RE: Cloverleaf TIS Response to Comments

Kellar Engineering (KE) comment responses in **blue** font.

Figure 9: 2040 Long Range Total Traffic

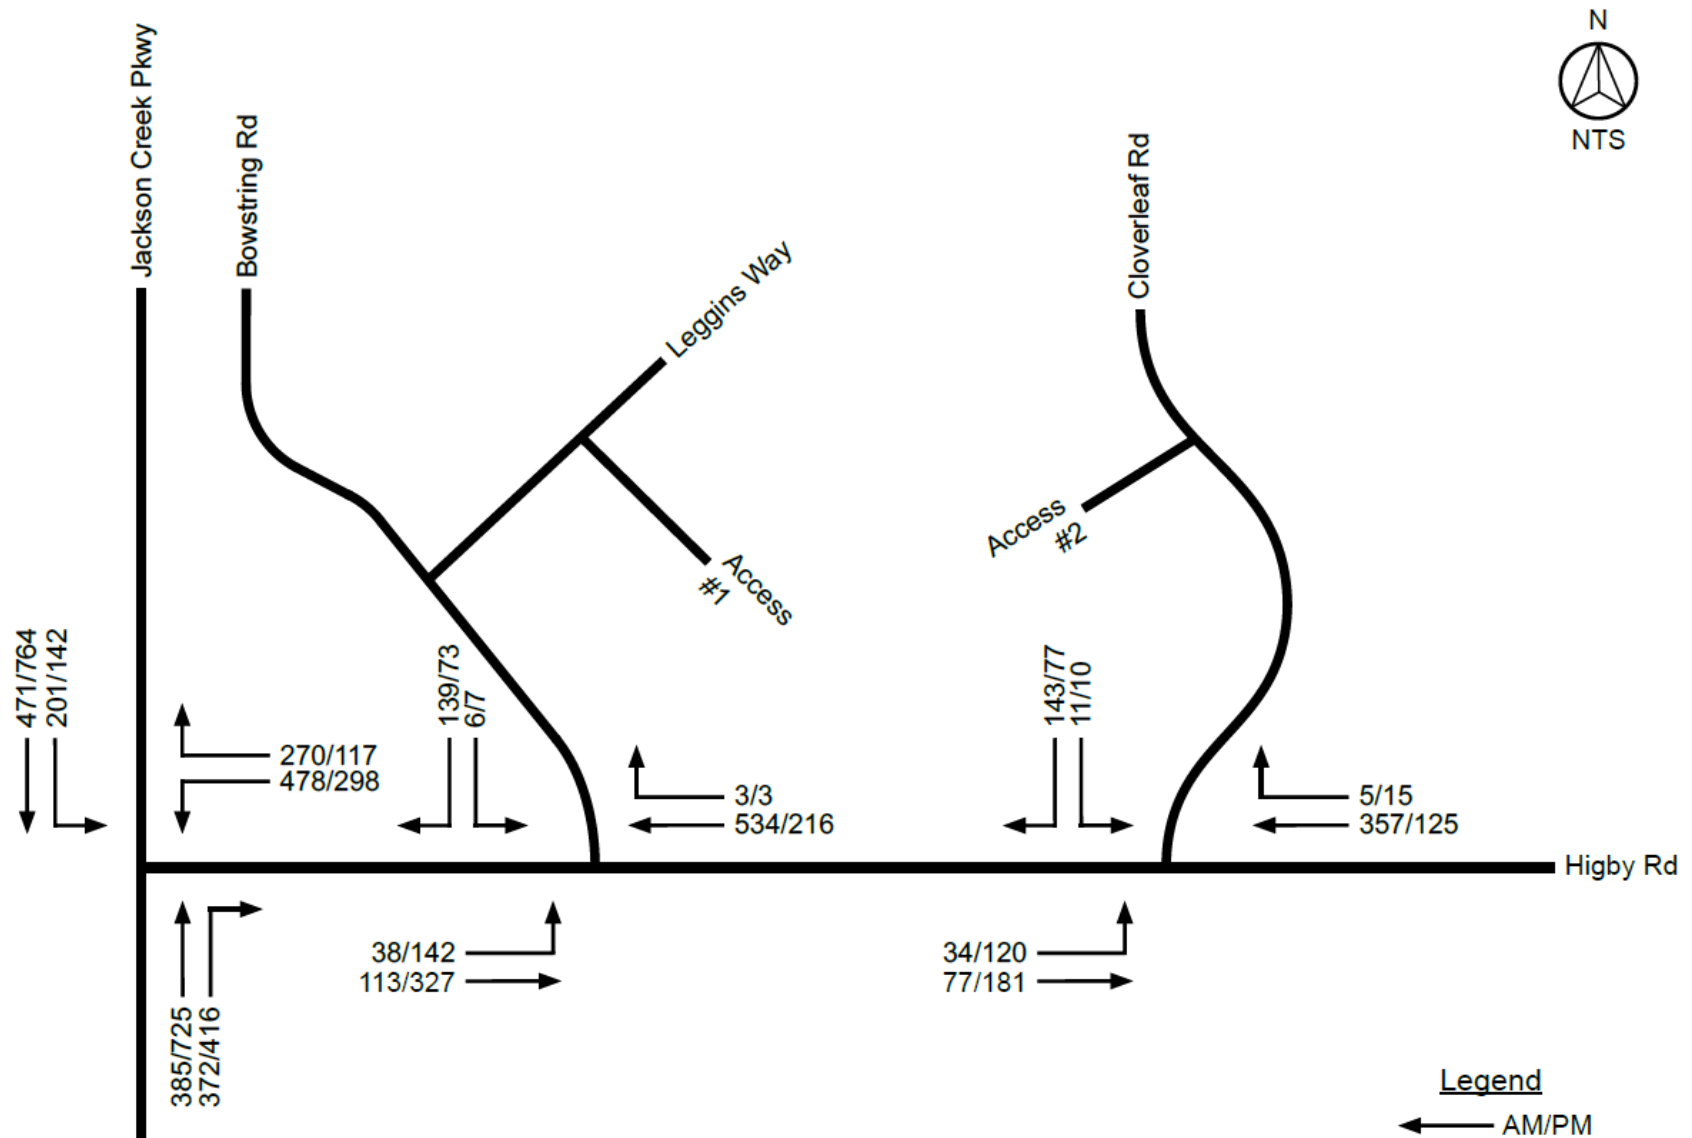
2. Comment. Update Figures 3, 4, 5, 8, and 9 to include Walters Point.

5. Comment. Add Walters Point in the TIS analysis. The applicant submitted a deviation request classifying Walters Point as Urban Local Low Volume with approximately 450 ADT with no supporting traffic analysis for the value stated.

Response. Figures updated accordingly.

Response. The ITE Trip Generation Manual was used to calculate the existing ADT on Walters Point. The average trip rates for the land use on Walters Point was used to approximate the traffic on Walters Point. Figures 3, 4, 5, 8, and 9 have been updated accordingly.
